CITY OF ALBUQUERQUE

Re: Vigil 3 Dwelling Units
Grading and Drainage Plan
Engineer's Stamp dated: 2/05/13 (H-23/D012B)

Re: Vigil 3 Dwelling Units
Grading and Drainage Plan
Engineer's Stamp dated: 10/31/12 (H-23/D012B)

GRADING AND DRAINAGE PLAN

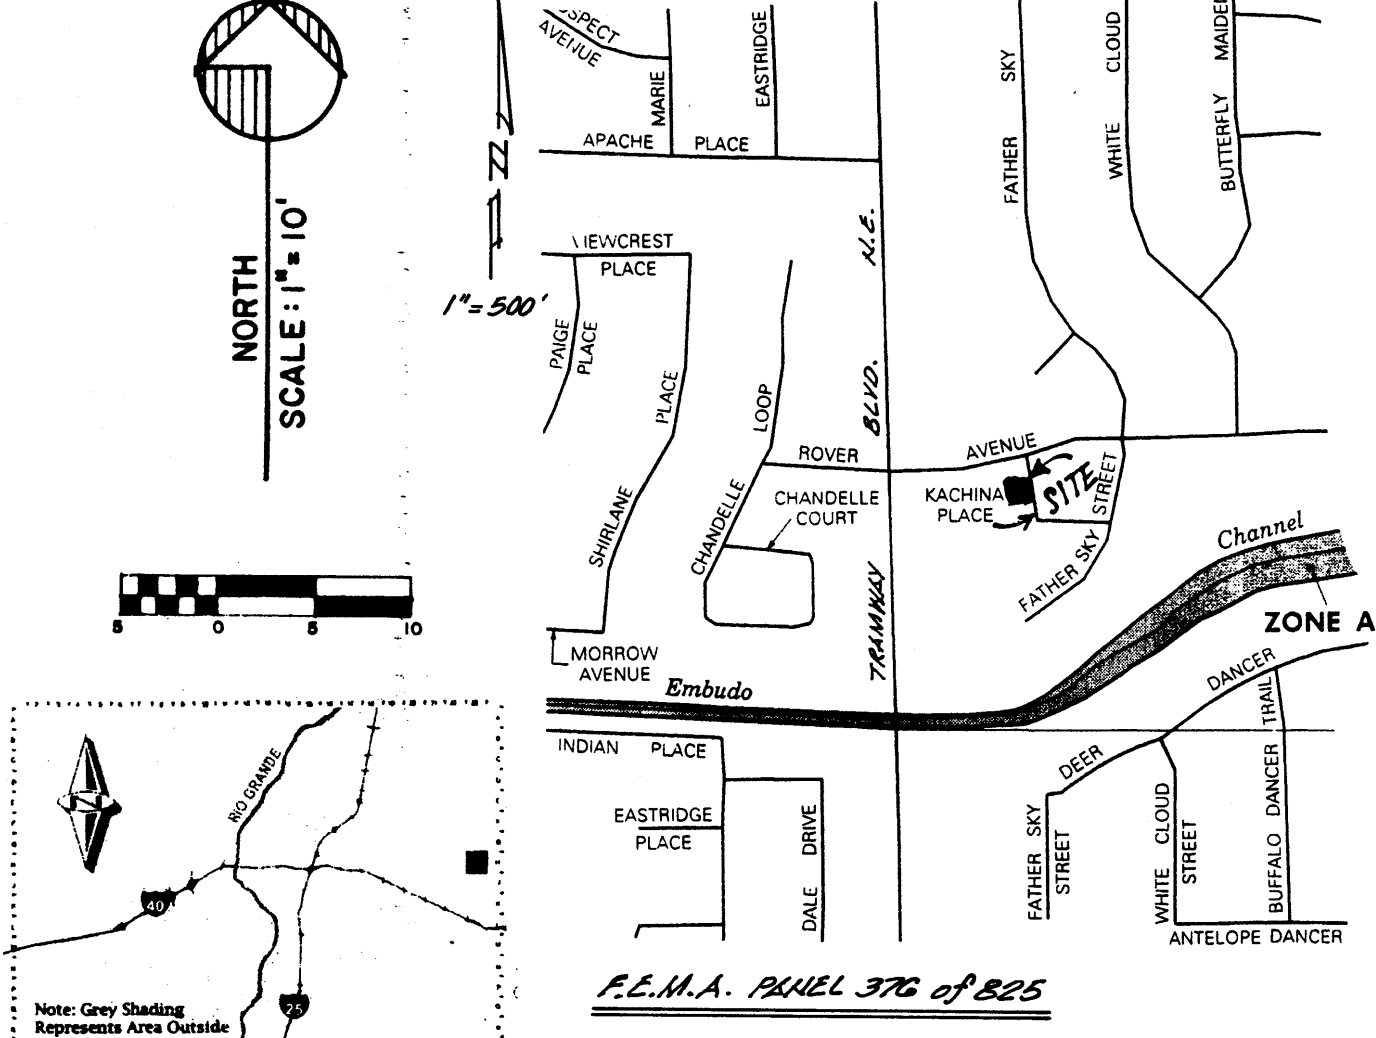
- The drainage does not match the approved grading and drainage plan received on 12/30/1980.
- A retention pond is required in the rear yard. *6 hr storm cc*
- All other flows are to be directed onto Kachina Place, after detention in the front yard.
